Ref: 6/2019/2041/FULL
Date: 22/10/2019

HISTORIC BUILDINGS AND CONSERVATION ADVICE

RE: 17A The Broadway, Hatfield, AL9 5HZ

The application is for the erection of air conditioning storage.

Drawing Title PROPOSED ELEVATION

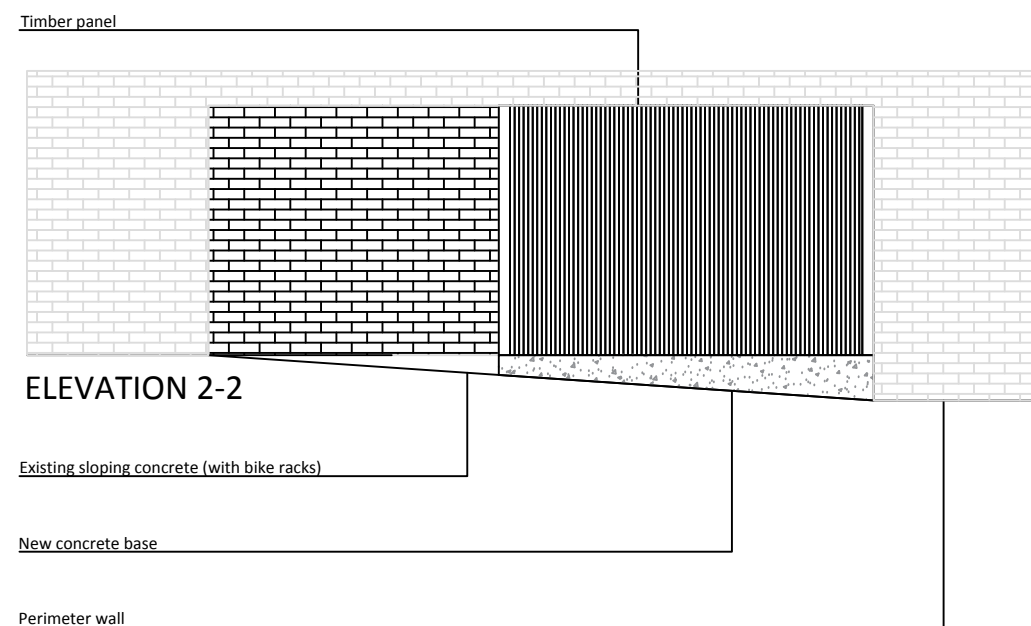
The proposed timber construction to conceal the air conditioning units is considered to be a sympathetic addition to this part of the conservation area. It will not have a detrimental impact on the area's character or appearance. No objections are raised as there is no harm caused to the significance of the conservation area, as per the provisions of paragraphs 190, 192 and 193 of the NPPF.
